Application: BE/40/22/PL
Location: Bersted: Former Bartons Infant School Romney Broadwalk Bersted PO22 9BH
Proposal: Demolition of former school building and erection of 21 No. new dwellings and associated car parking, cycle parking and landscaping. This site is in CIL Zone 4 (Zero Rated).

Refusal due to insufficient ecological information on European Protected Species (Bat and Otter) and Protected species (Water Vole).

Photo 10: Showing the mature Alder trees to the north west of the site (T6)

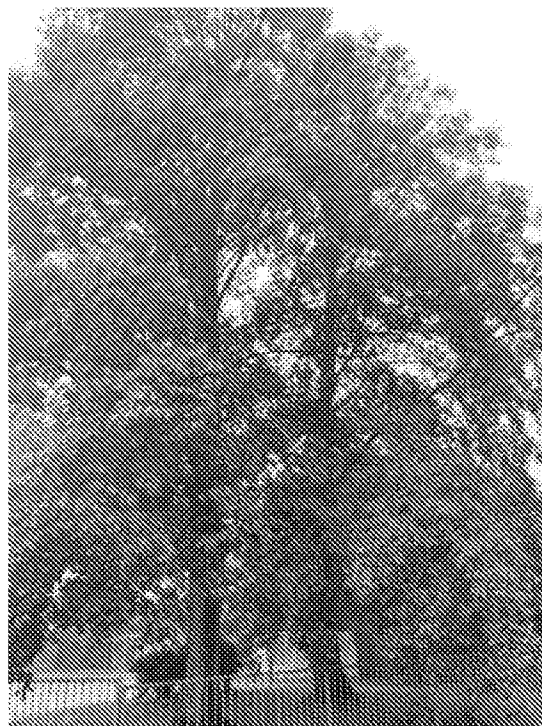
Additionally, section 3.3.3 of the Preliminary Ecological Appraisal (Ecology & Habitat Management Ltd, March 2022) states there are a number of trees with low bat roost potential on site and refers to the tree descriptions in section 3.1.4 which relates to the target notes T1 – T6. The Tree Removal and Proposed Tree Plan (HED, January 2022) appears to show all trees labelled on the map within the ecology report as T1 – T6 as being removed. The Preliminary Ecological Appraisal (Ecology & Habitat Management Ltd, March 2022) states *“If the mature trees with a low roost potential are required to be removed then this should be soft felled; felled in sections and lowered to the ground. With the cut sections left in situ overnight”*. Without an emergence survey or an aerial inspection by a licenced bat ecologist to fully rule out the potential presence of bats roosting within these trees with low roost potential, we are not satisfied that the recommended mitigation measures are proportionate to prevent injury and or death to bats. We recommend further detail regarding the proposed soft felling is provided, this should include photos of the features with bat roost potential, which could form part of a Construction Environmental Management Plan (CEMP): Biodiversity, to be implemented. This could be provided as prior to determination or could be conditioned should the LPA be minded to grant permission.
